AB/142/25/HH

59 Tarrant Street Arundel BN18 9DJ

Extension at rear of property, loft conversion and various changes to fenestration (This application may affect the character and appearance of the Arundel Conservation Area).

GROUND FLOOR - PROPOSED

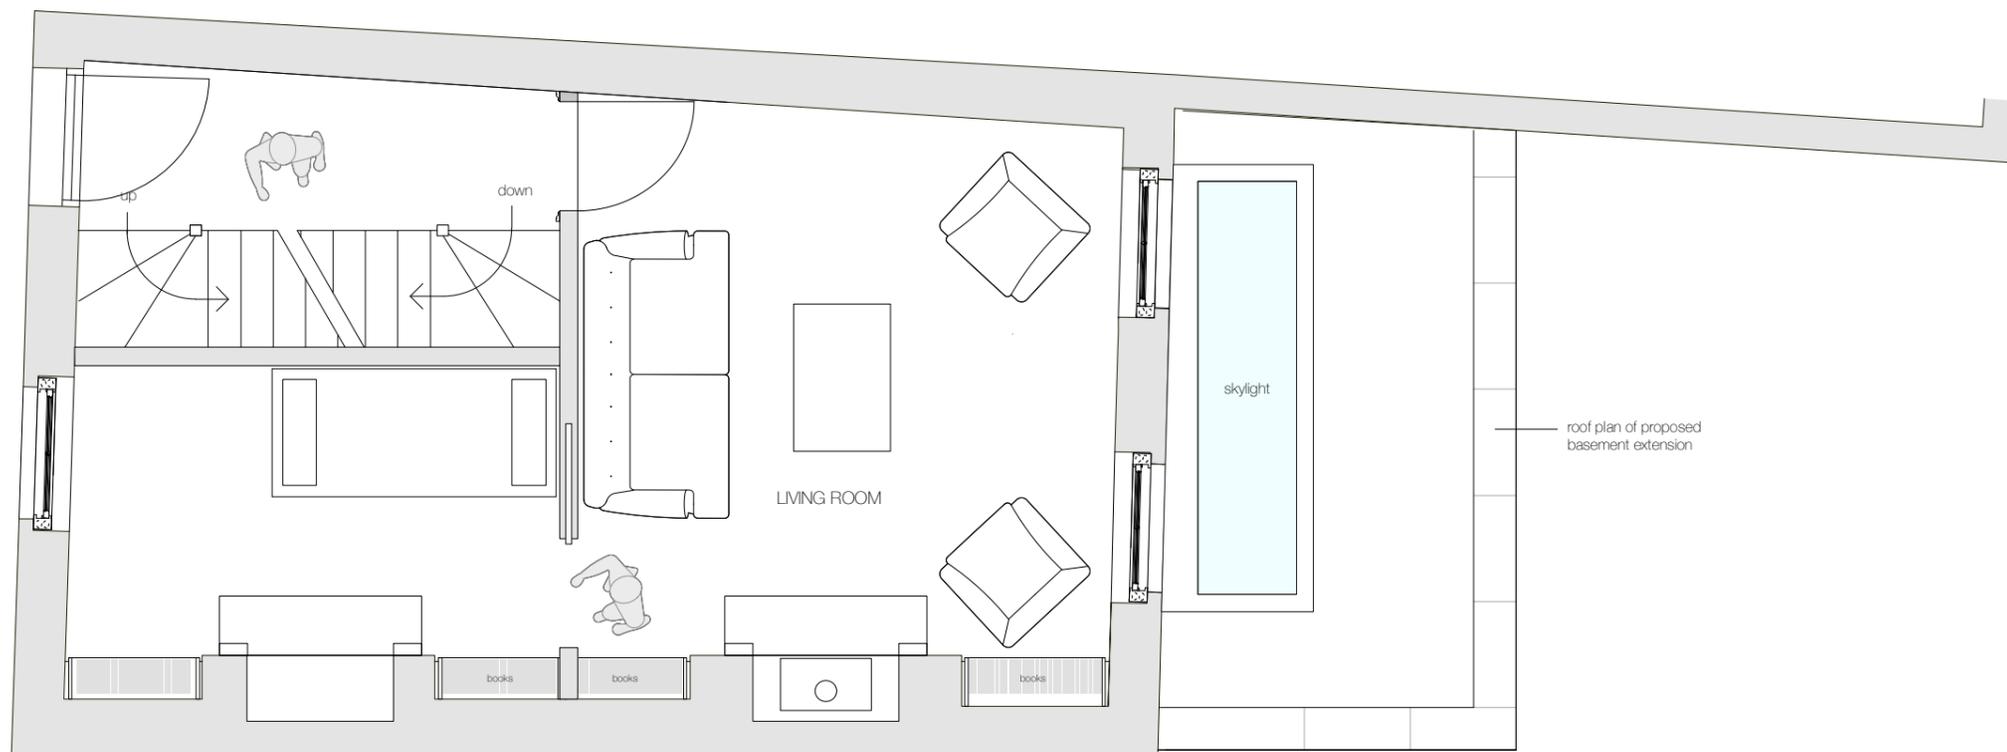
The existing 1960s rear kitchen extension is of limited architectural value or amenity. The replacement would be a full-width single-storey rear extension, and it is positive to note that it would be constructed from reclaimed brickwork. Ordinarily, I would object to the inclusion of an overlarge dormer window. However, in this particular instance, the proposed dormer on the rear elevation is unlikely to be visible from public viewpoints and would only be seen from a limited number of private ones. The front dormer and rooflight, whilst large replicate those found in the neighbouring houses and would not be clearly seen from the road. The insertion of the additional window, along with the dormer would increase the number of openings on the front elevation, but if carefully designed and installed could be acceptable.

ELEVATION AND SECTIONS THROUGH SASH WINDOW
1:20 @ A3

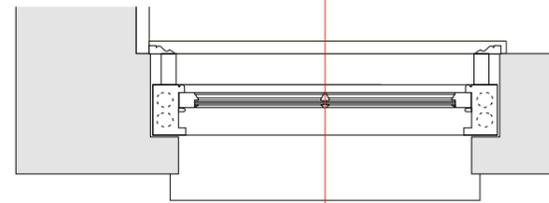
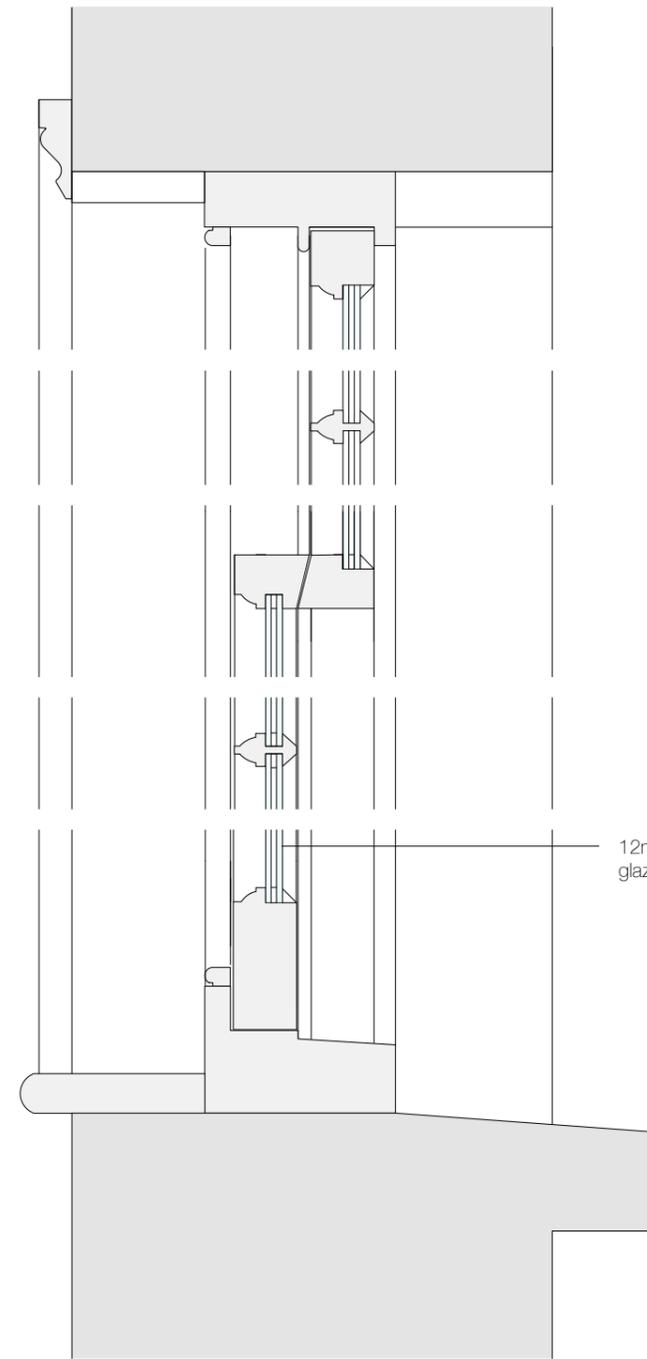
It is clear that the design incorporates fine detailing and well-proportioned fenestration, and the use of high-quality external materials is proposed to match the existing house. I would also expect details such as the window cill to be accurately replicated. This is a positive element of the scheme.
